WEST SUSSEX COUNTY COUNCIL CONSULTATION

TO:	Arun District Council FAO: Michael Eastham
FROM:	Stephen Gee WSCC - Highways Authority
DATE:	29 April 2021
LOCATION:	Tye Lane Walburton BN18 0LU
SUBJECT:	WA/93/20/PL Alternative access & emergency access along with minor highway works following WA/95/18/RES. This site is in CIL Zone 2 (Zero Rated) as other development.
DATE OF SITE VISIT:	n/a
RECOMMENDATION:	More Information
<u>S106</u> CONTRIBUTION TOTAL:	TBC

Drawing Title:
**PROPOSED ACCESS IMPROVEMENTS
- TYE LANE/AVISFORD PARK ROAD**

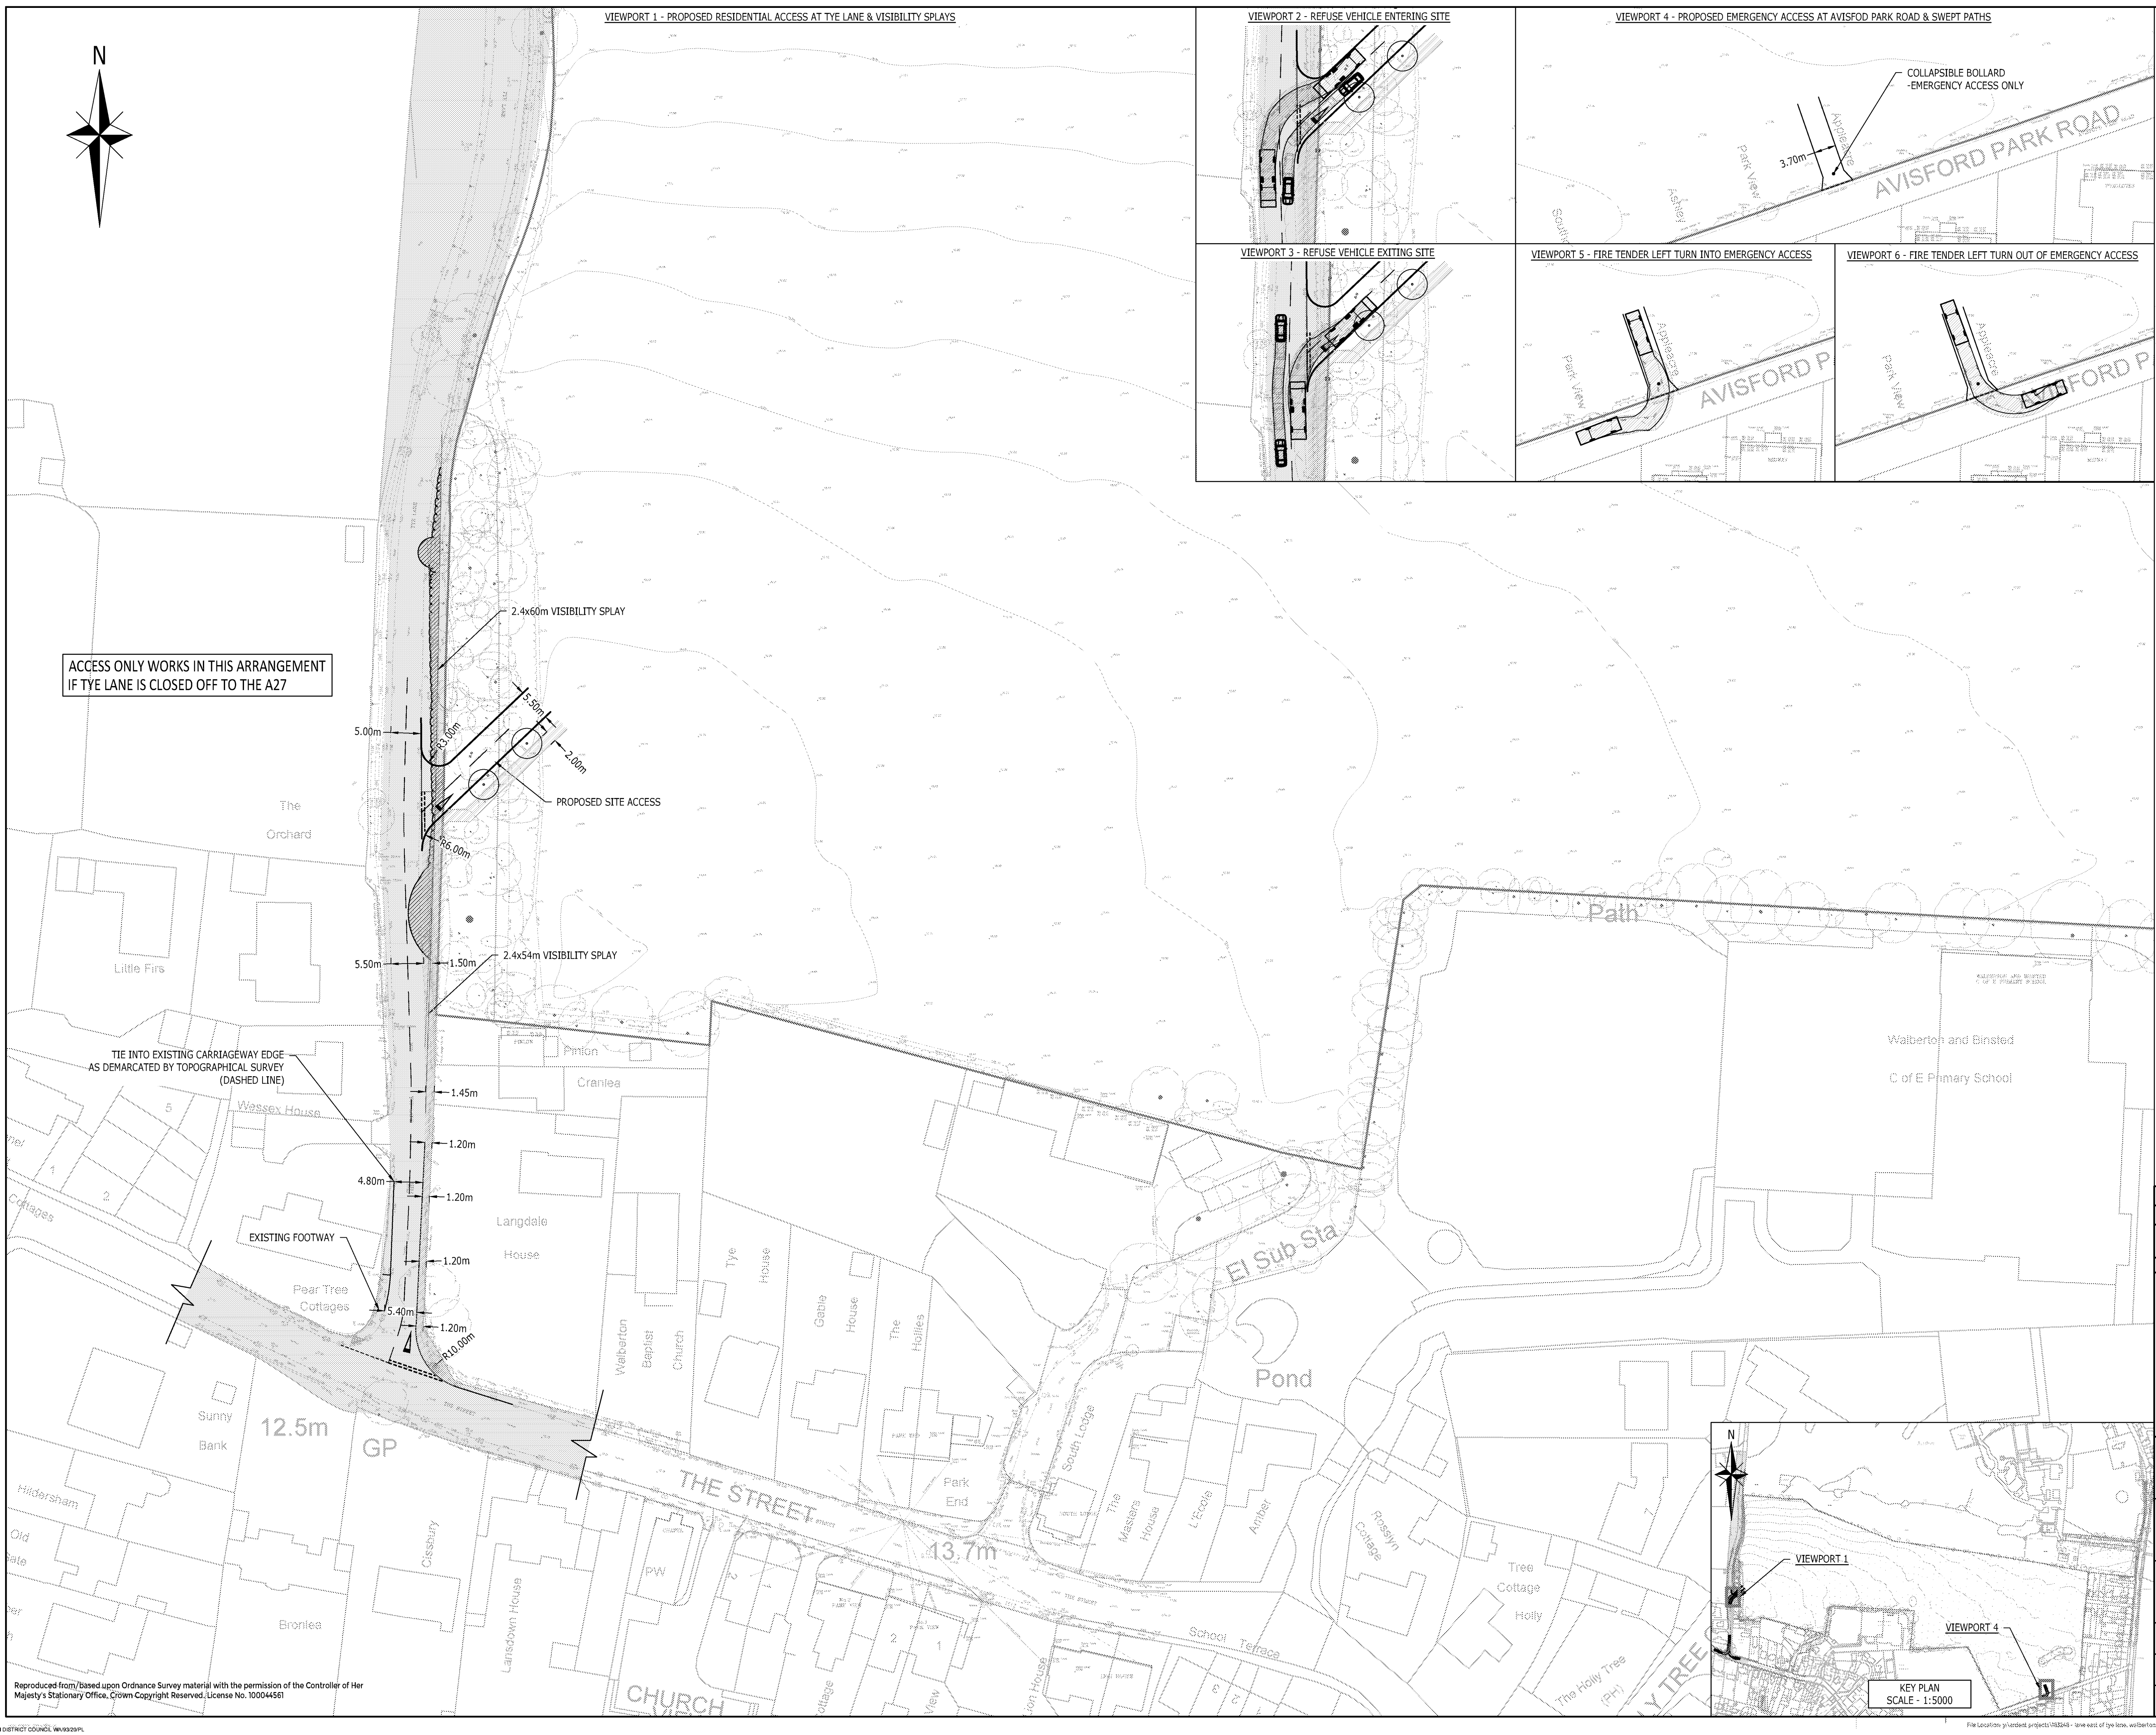
The minimum footway width along Tye Lane has been increased to a minimum of 1.2m for approximately 25m by reducing the running carriageway to a minimum of 4.8m; given alternative pedestrian access is available and the planning permission would only be implemented should the preferred route announcement be confirmed and implemented and as such Tye Lane would be closed to the North then no concern is raised.

Vehicle tracking has been provided for the emergency access which shows a Fire Tender can utilise the access and internal link within the development.

A1 Scale	Date	Designed by
1:500	23.02.21	DV
Drawn by	Checked by	Approved by
DV	DH	KM
Drawing Number	183248-004	Rev A

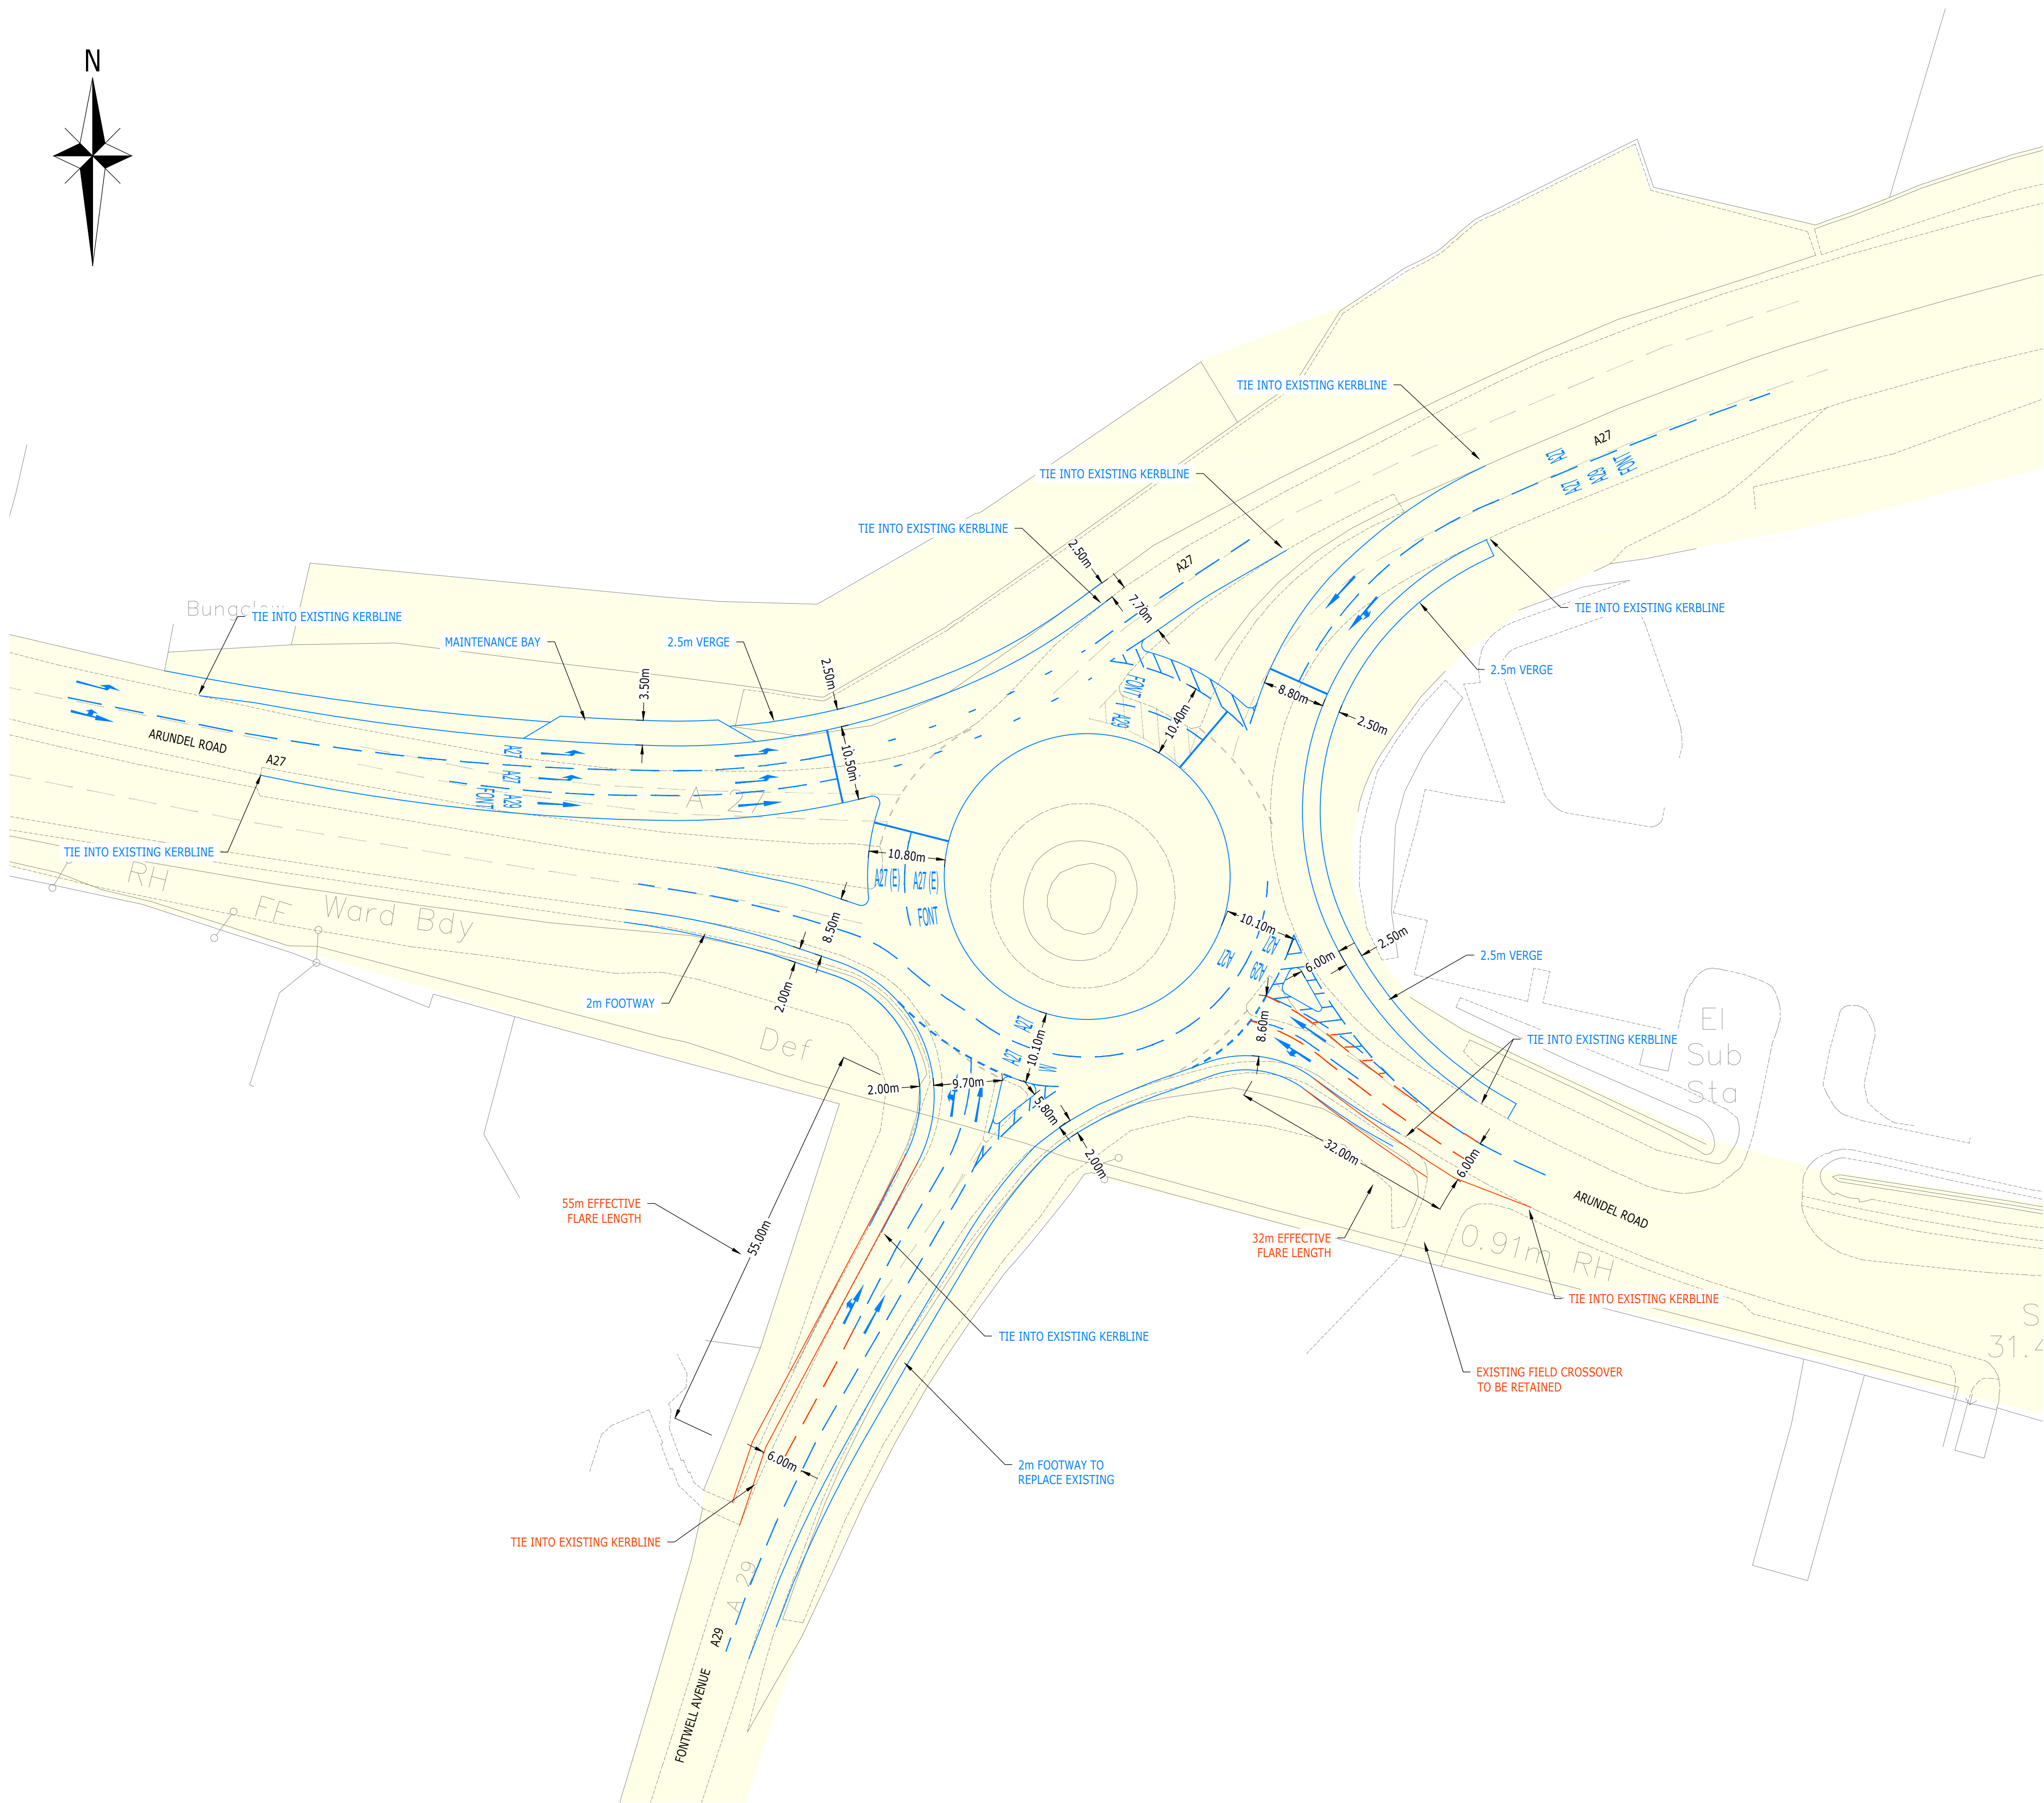
A mitigation scheme of widening the effective flares of the Arundel Road and A29 approach has been proposed and modelling provided to assess its impact.

WSCC raise concerns that the baseline data utilised does not accurately reflect the current Arundel Bypass Preferred Route Announcement scheme as the flows utilised in the modelling come from the Arun Local Plan Arundel Bypass model run which does not include the closure of Tye Lane and Yapton Lane therefore the wider rerouting (especially on Arundel Road) would not be included.

As the planning application would only be implemented should the Arundel Bypass be approved then this should form the baseline assessment which it currently does not.

Further Information is requested to determine the developments impact on the A27/A29 Fontwell East junction with the Arundel Bypass Flows that accurately reflect the Preferred Route Announcement scheme.
